WELWYN HATFIELD BOROUGH COUNCIL – DEVELOPMENT MANAGEMENT
DELEGATED REPORT

APPLICATION No: S6/2013/2243/FP

SITE ADDRESS: 79 Bramble Road, Hatfield

DESCRIPTION OF DEVELOPMENT: Two storey rear extension, single storey side extension

FIRST FLOOR REAR EXTENSION AND SINGLE STOREY SIDE EXTENSION
79 BRAMBLE ROAD
HATFIELD
DRAWING NO BR/02
DRAWING SIZE A2
SCALE 1:50-1:100
DATE - OCTOBER 2013

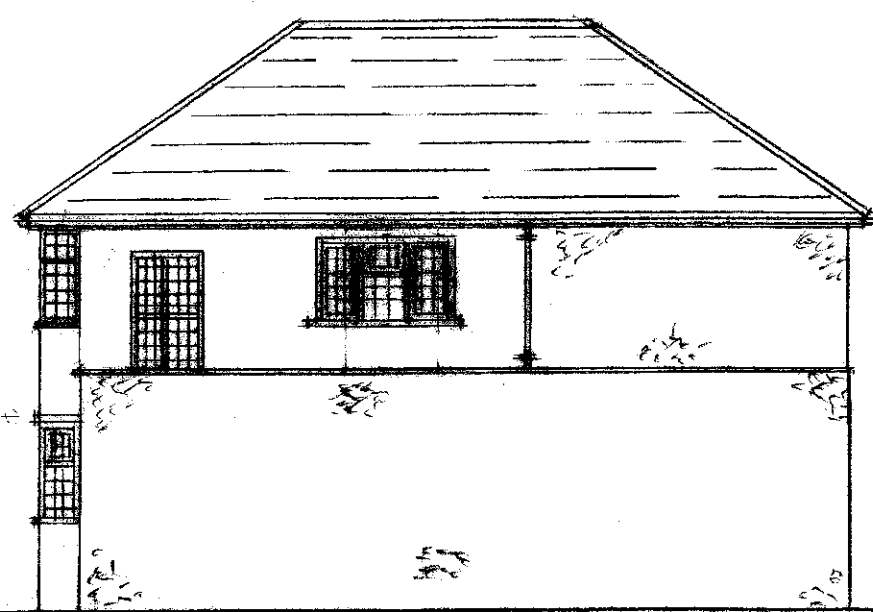
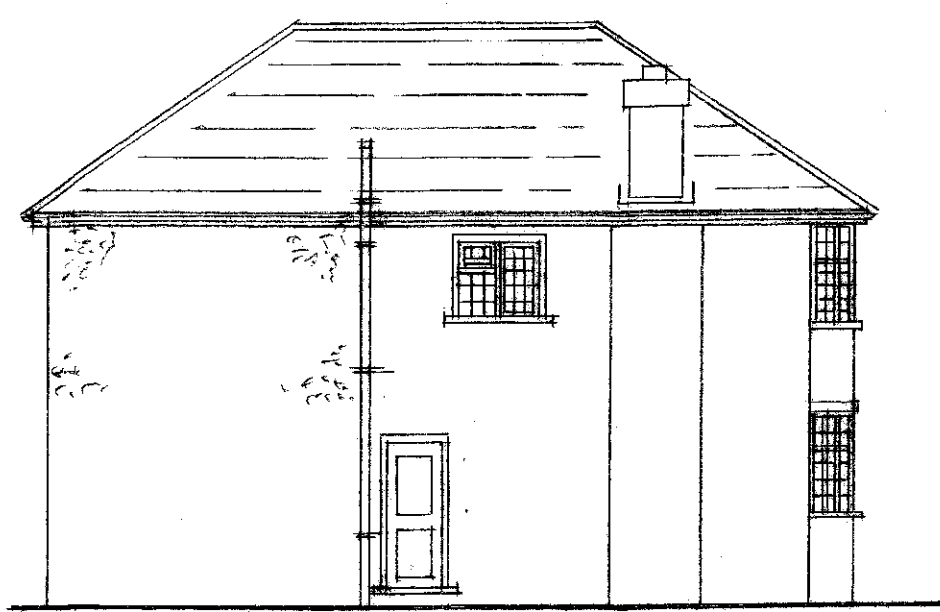
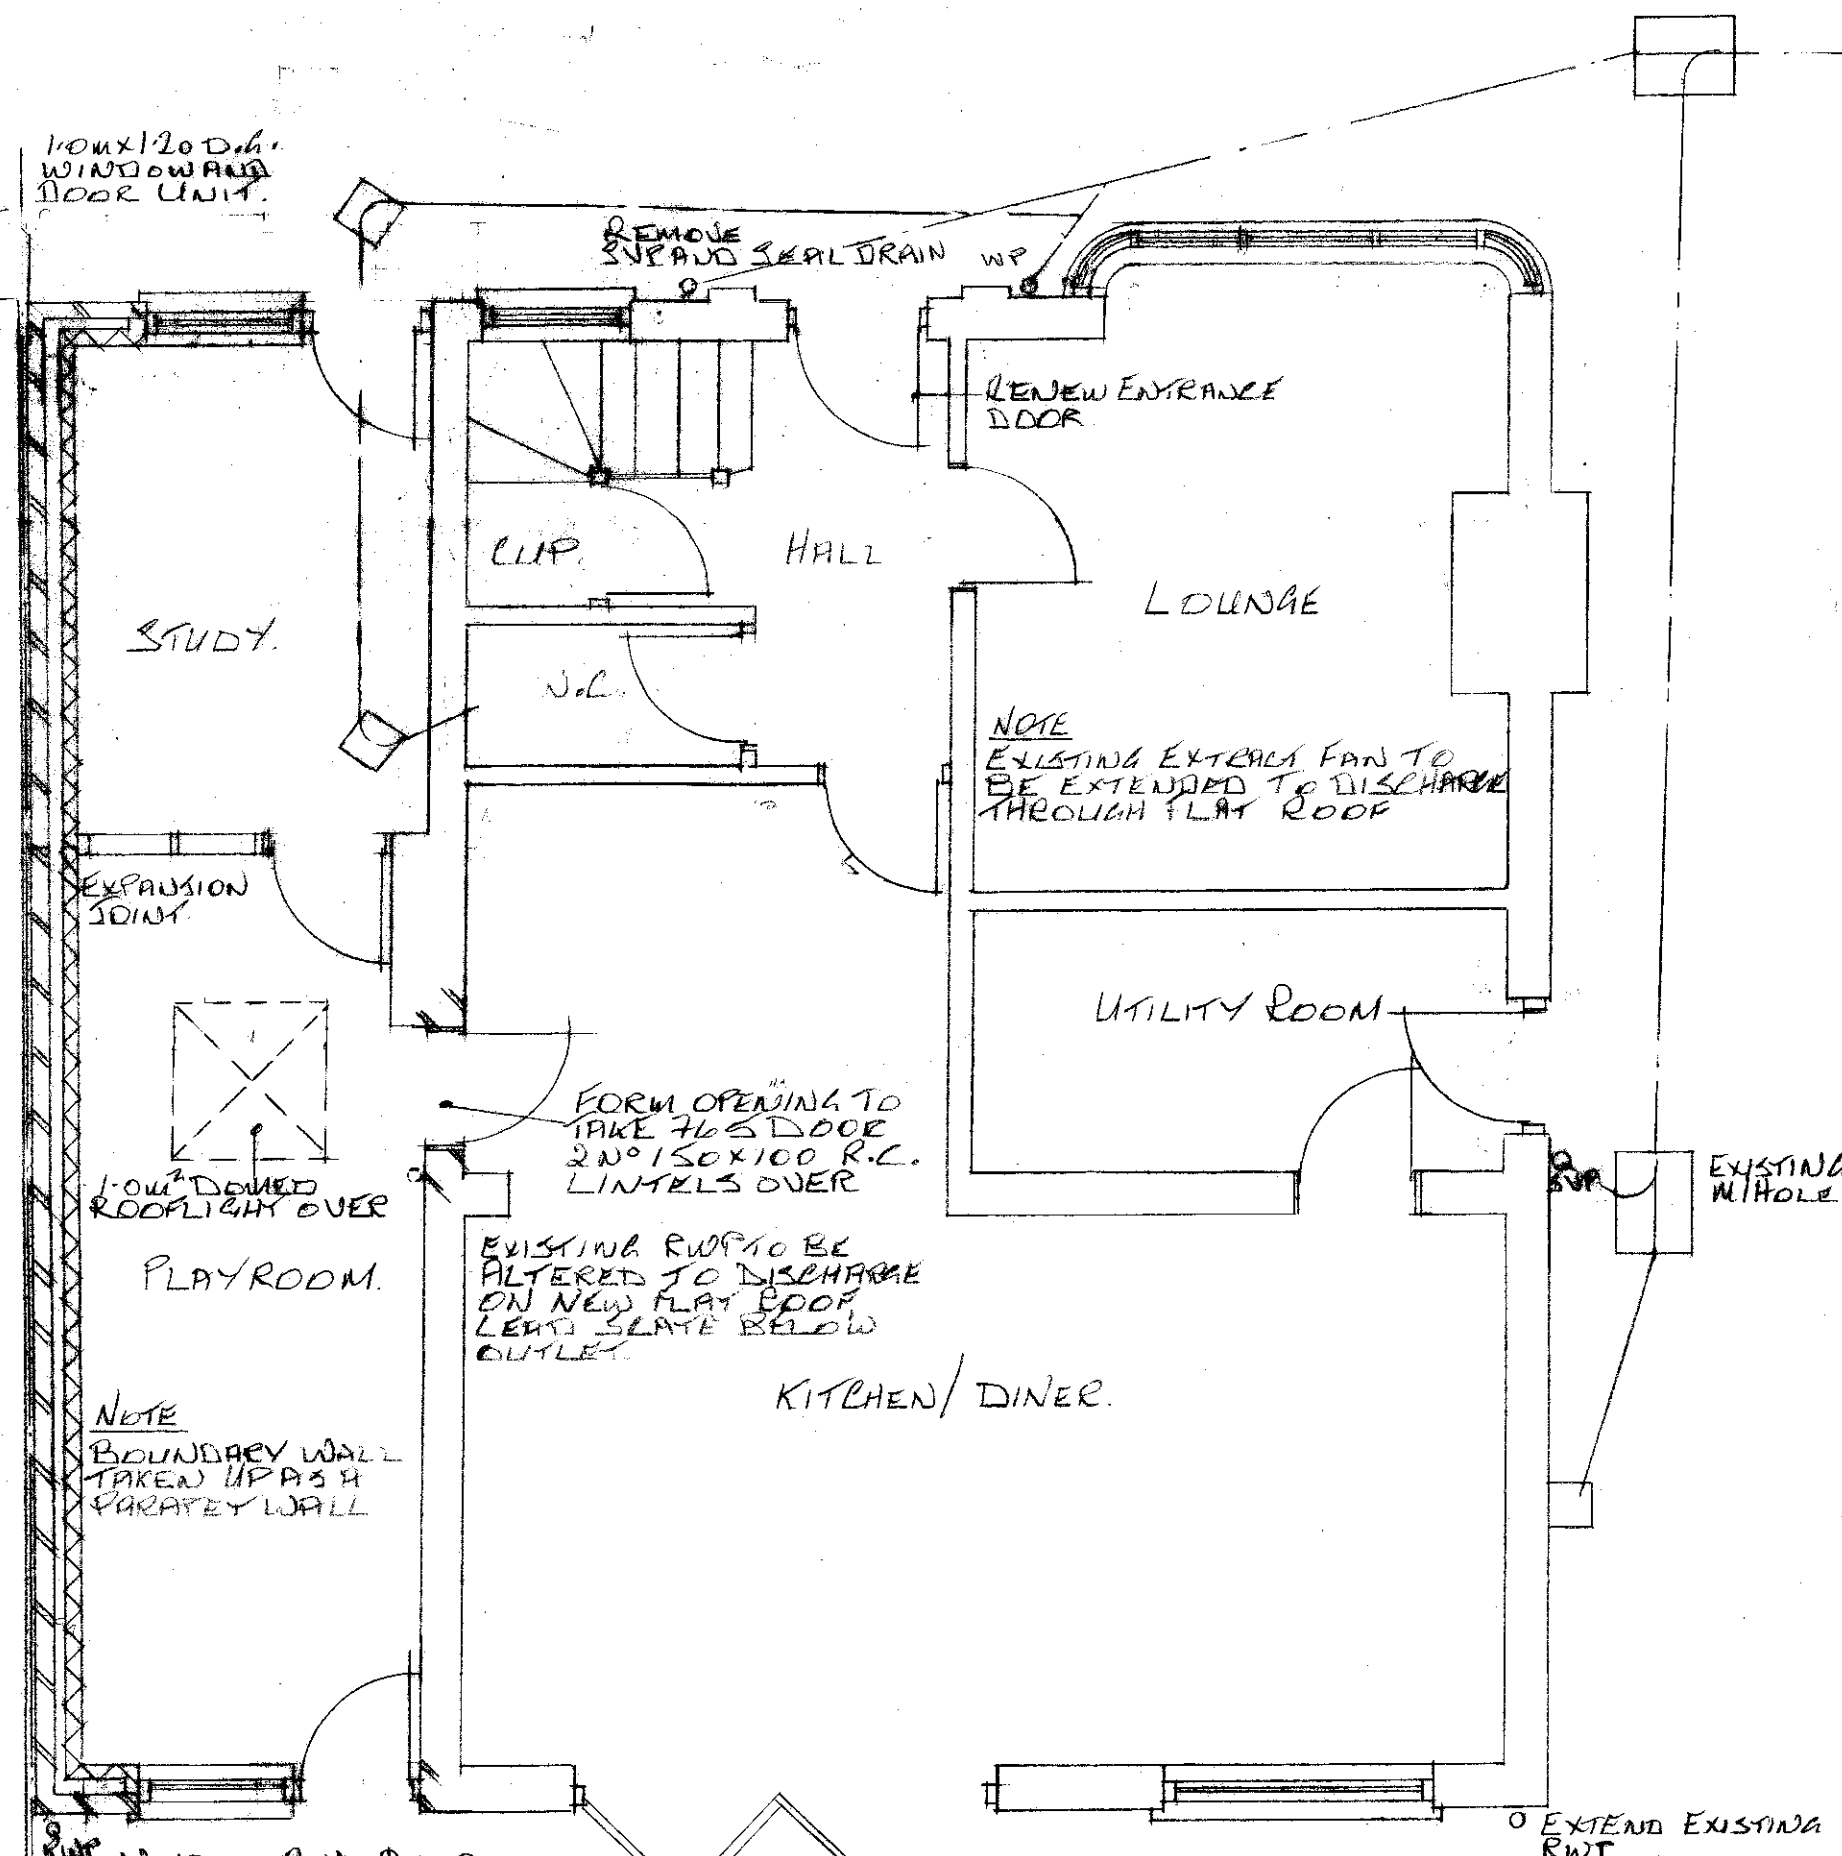
The single storey side extension would extend out from the side of the host dwelling, in line with the existing front building line (not including the projecting bay window element). It would have a flat roof, which would tie in well with the property's existing horizontal emphasis, and to the front it would feature a door and a window. The neighbouring property to the north-west has also extended to the side, as have other properties in the street. As such, it is not considered that the single storey side element would detract from the character and appearance of the area. This is subject to a condition to ensure matching materials are used in its construction.

The two storey rear element would be located to the rear of the host dwelling. Whilst it may be partially visible in the gap between the host dwelling and its neighbour, it would not be a prominent feature in the streetscene and, provided that matching materials are used in its construction, it is not considered that it would detract from the character and appearance of the wider area.

Given that this property has also extended to the side it is not considered that their residential amenity would be detrimentally affected by the proposed single storey side extension. With regards to the two storey rear element, it is considered to be sufficiently removed from the shared boundary so as not to affect this property in terms of overbearing impact or loss of outlook. There would be no windows on the side elevation (which a planning condition can ensure remains the case in the future) and therefore overlooking would not pose a problem either.

3. C.5.2 – The render, detailing, guttering, soffits and other external decorations of the approved extension/alterations shall match the existing dwelling, unless otherwise approved in writing by the Local Planning Authority.

4. C.7.10 - Other than the windows shown on the approved drawings to which this planning permission relates, no windows or other openings shall be inserted into the side elevations of the extension hereby permitted without the prior written consent of the Local Planning Authority.

Site Plan 1:200

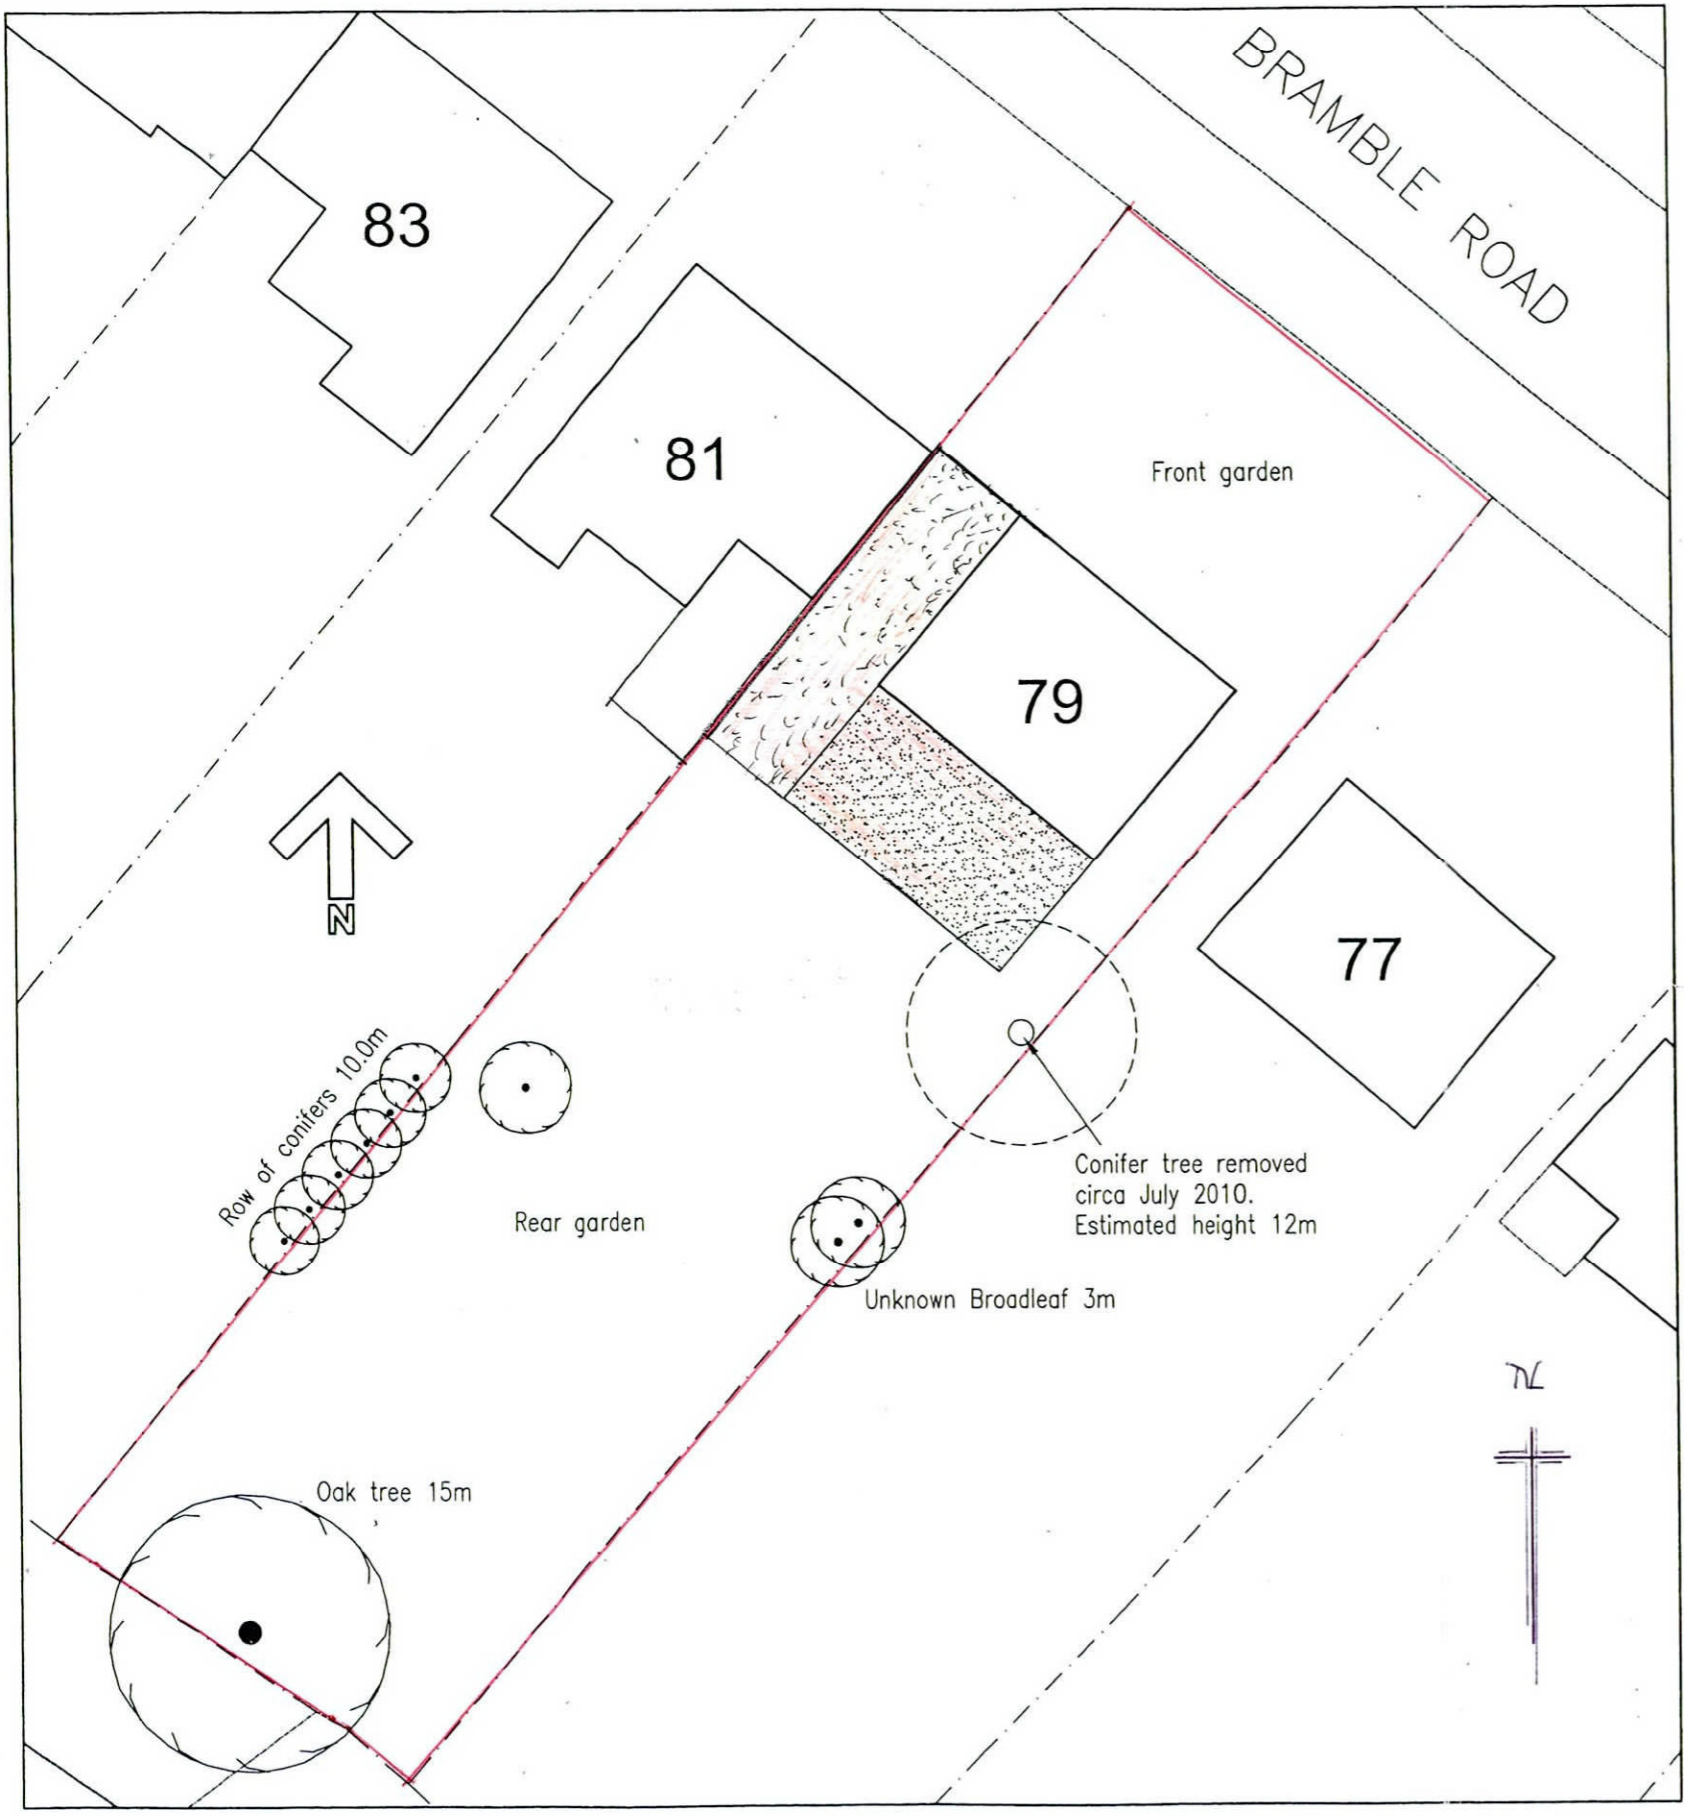
b) The main properties which may be affected by the proposal are the two neighbouring properties, numbers 77 and 81.

This property is located to the south-east. It has also been extended to the rear (planning permission granted in 1990). The proposed two storey rear extension would extend out from the rear of the host dwelling by nearly 4 metres. Given the separation distance between the two properties it is not considered that the proposed rear extension would appear overbearing to this property or that it would lead to any loss of outlook. There would be no windows on the side elevation (which a planning condition can ensure remains the case in the future) and therefore overlooking would not pose a problem either. In terms of loss of sunlight, given that the proposed extension would be to the north, this would not be an issue. Overall, the impact on this property is judged to be acceptable.

This property is located to the north-west. It has also been extended to the side and rear, with the side extension abutting the shared boundary with a parapet wall design. The occupier of this property has raised concerns about the proposed extensions to the host dwelling affecting their land. However land ownership issues are not a planning consideration and therefore cannot be taken into account in the determination of the application.

c) The proposal would create 1 additional bedroom in the host dwelling. The application site is within Parking Zone 3 as designated in the Welwyn Hatfield District Plan 2005 and the guidance states that a 4 bedroom dwelling requires up to 3 parking spaces. The driveway for the property comfortably fits 2 cars which is below the recommended number. Nevertheless, there are parking restrictions during term-time along Bramble Road and as such, it is not considered that the proposal would not give rise to parking problems in the street. As such, the proposal is considered to be acceptable in this respect.
